15 December 2023

**Re: SSD-8996 – Mod 1 - Loreto Normanhurst - 91-93 Pennant Hills Road and 6-12 Mount Pleasant Avenue, Normanhurst – Response to latest amendment**

DATE: 29/01/2021

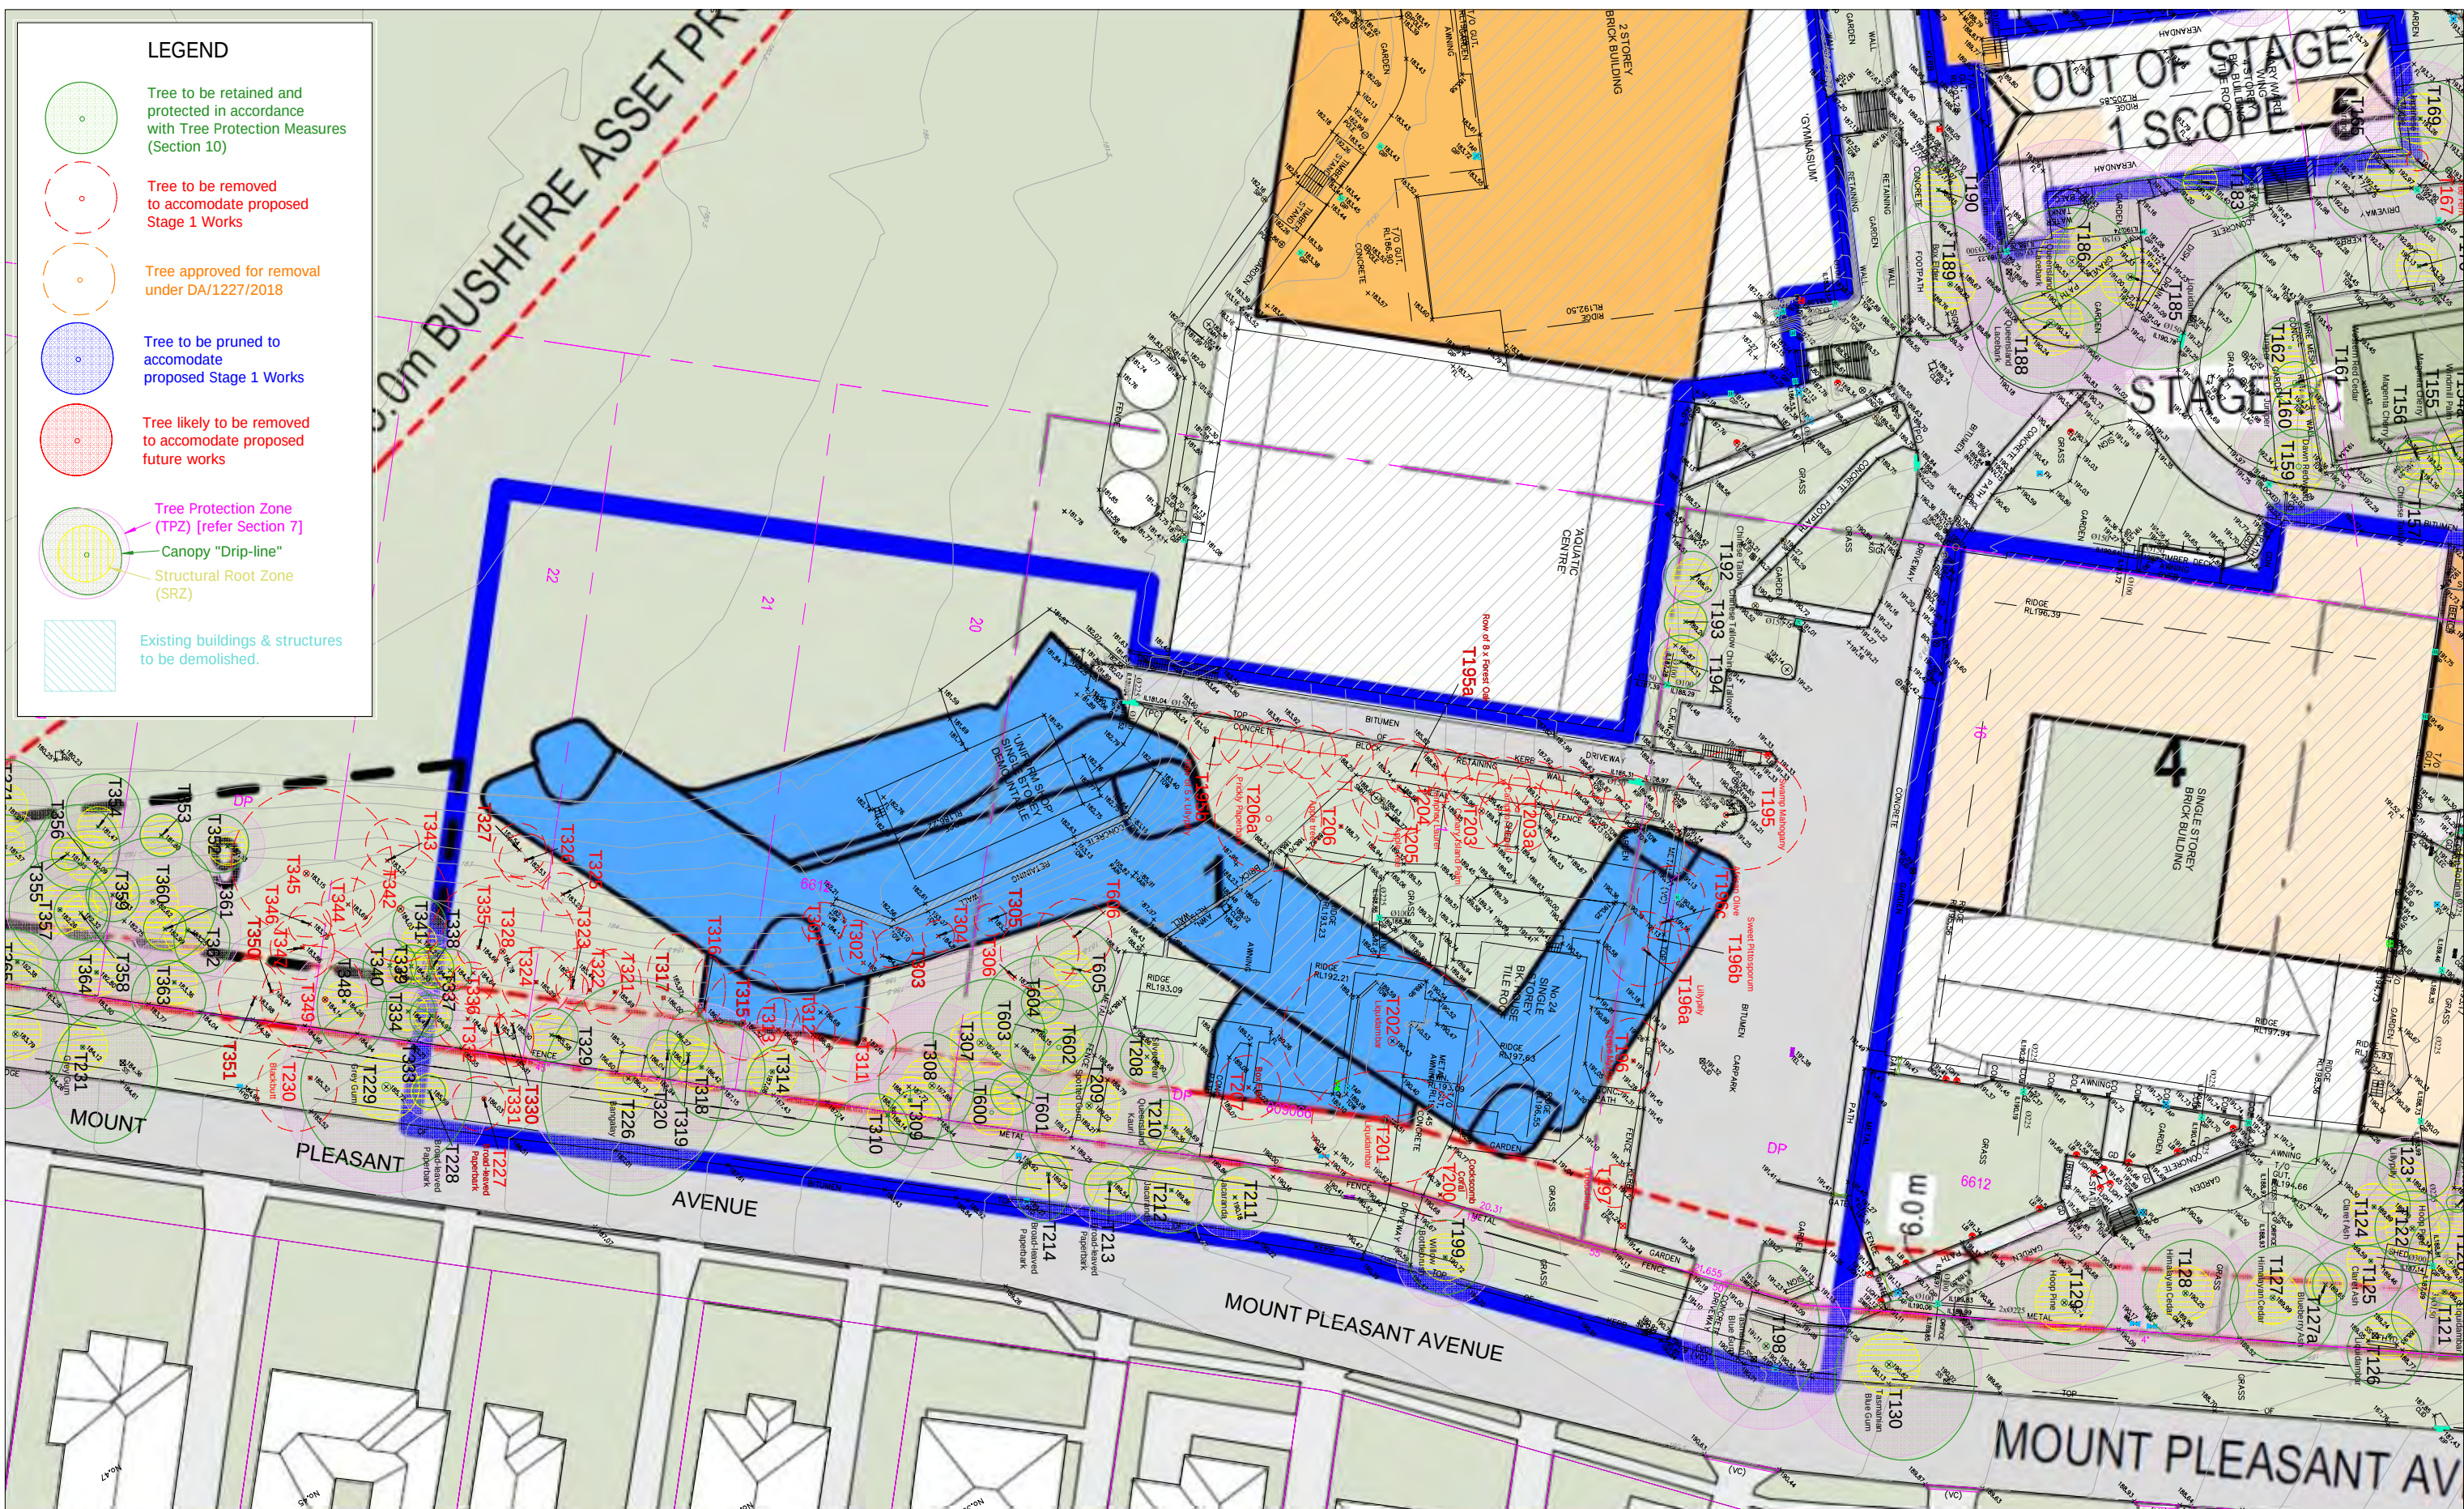
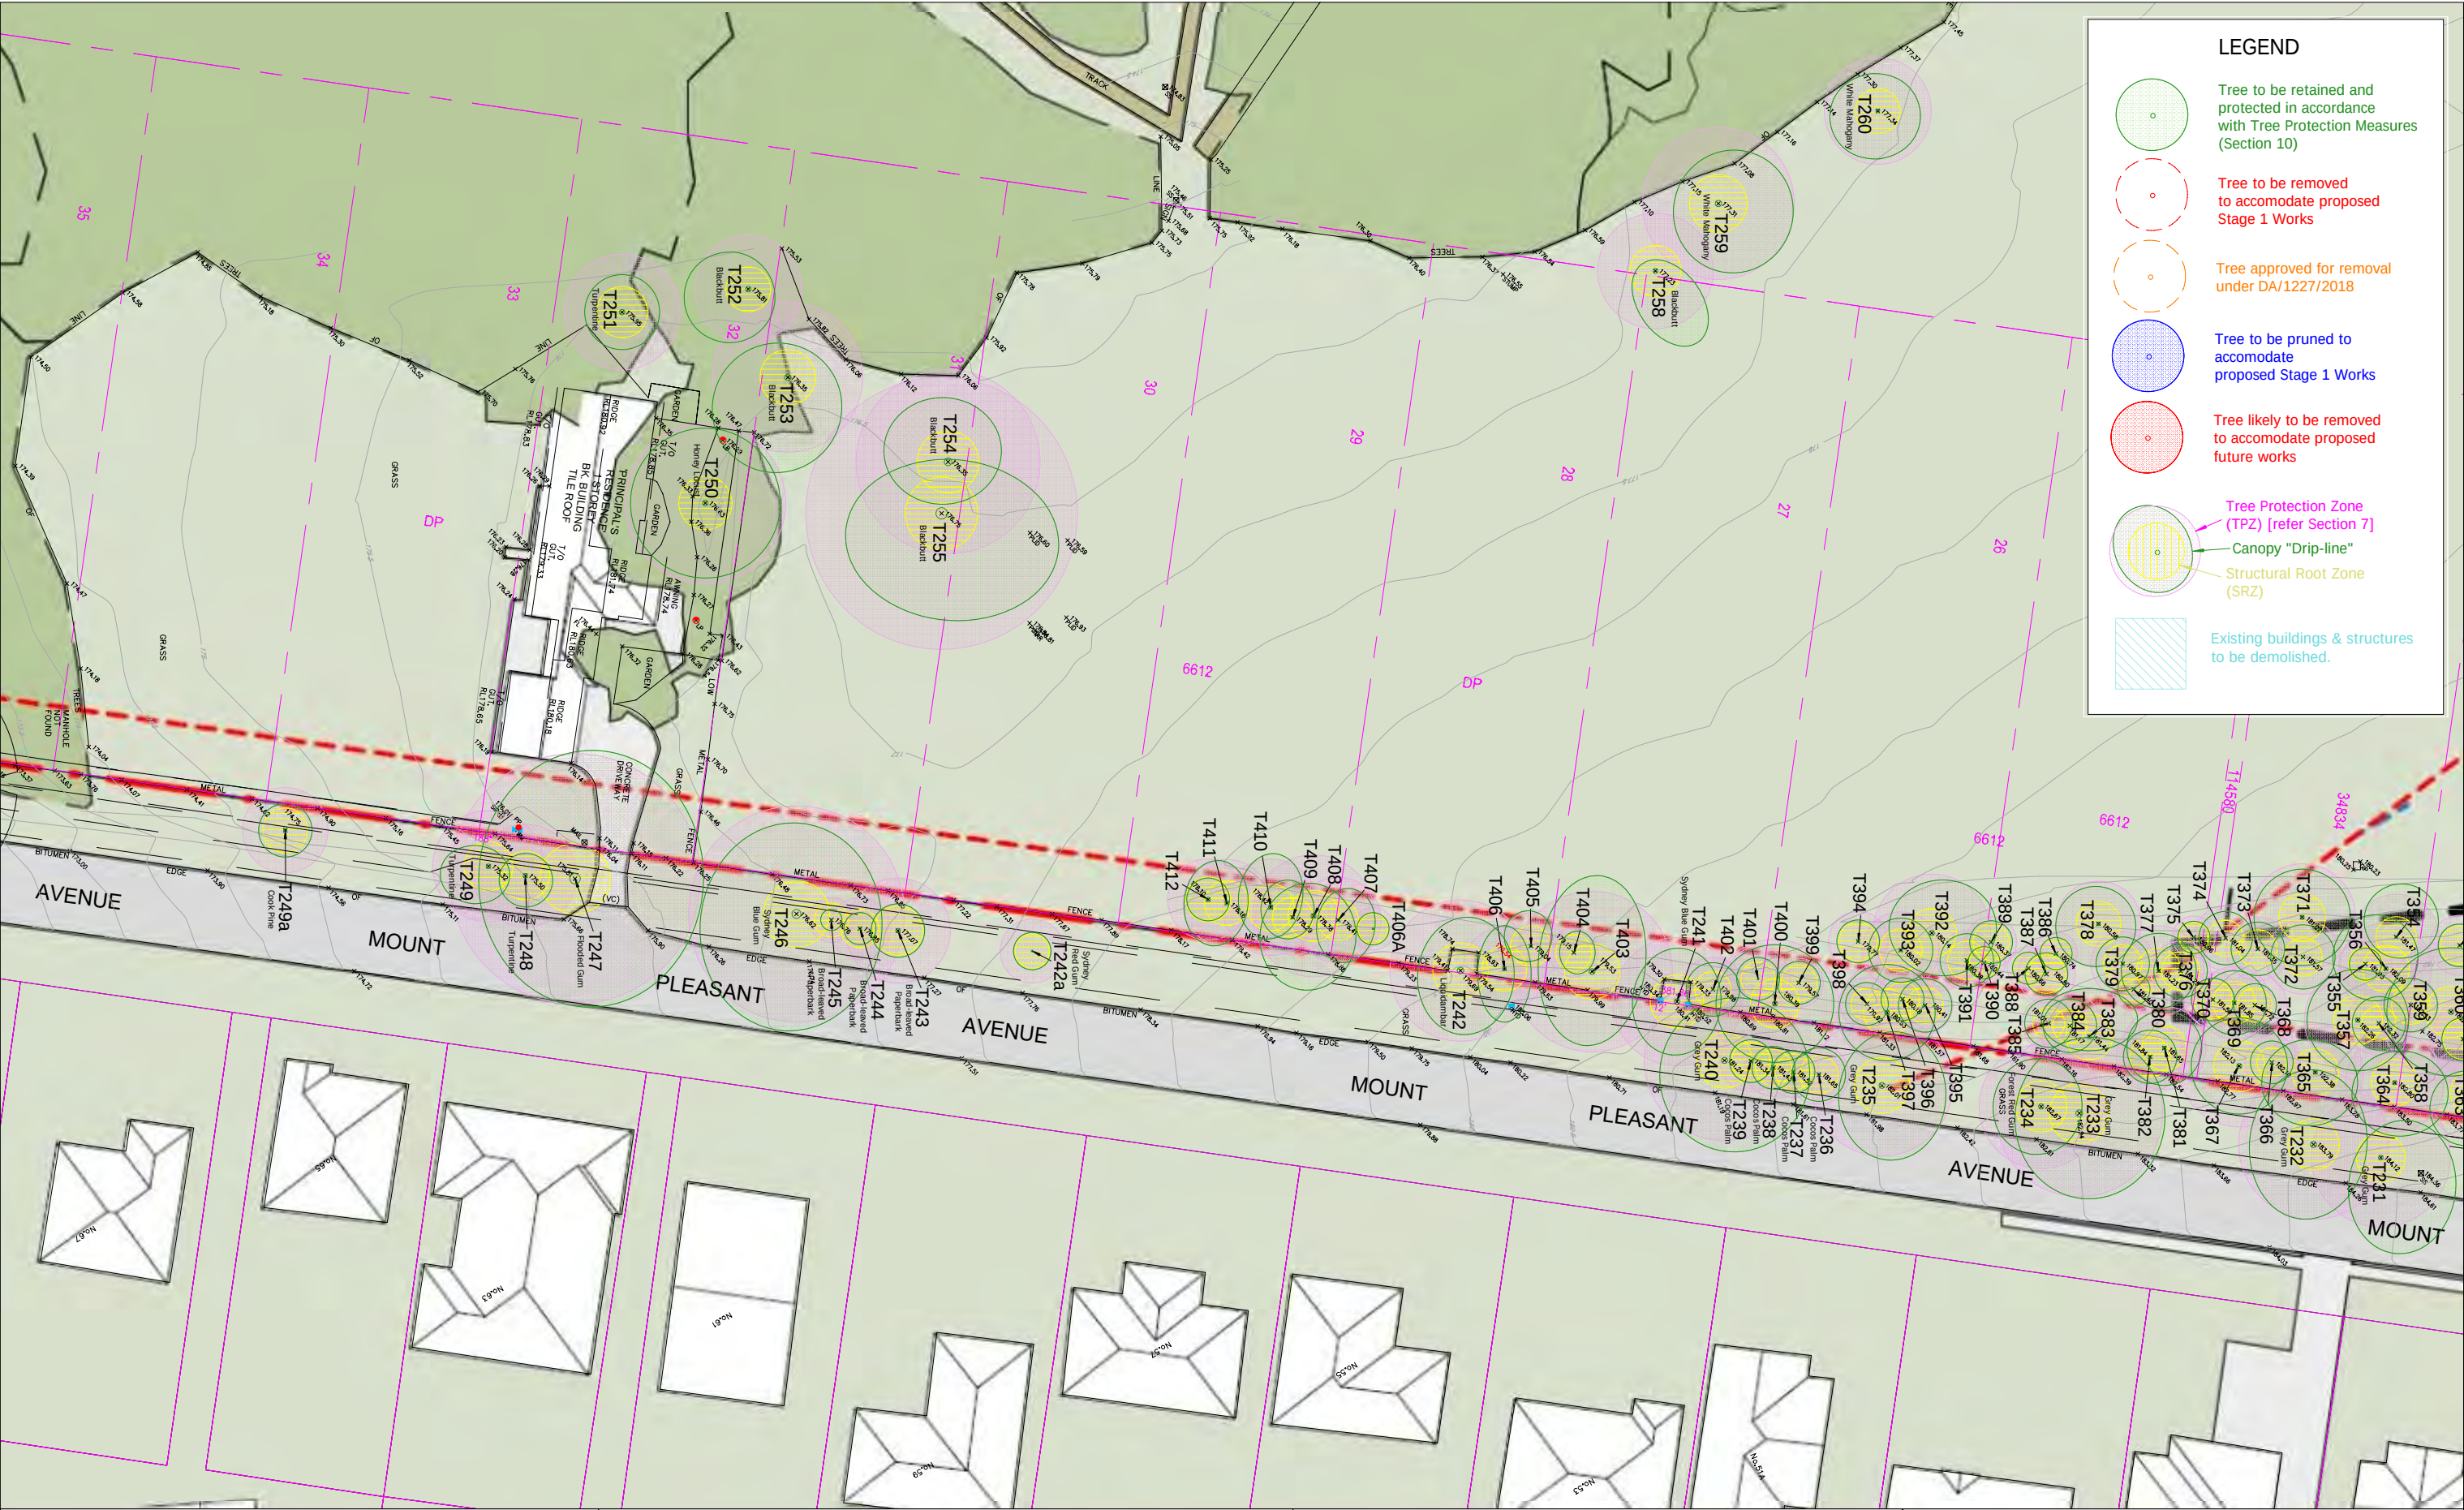
- Numerous trees are plotted for removal to accommodate fill batter for a pedestrian pathway and driveway ramp. It is suggested the Department review retaining more of these trees by utilising sensitive tree construction techniques and utilising different construction materials/techniques such as pier and beam instead of fill batter.
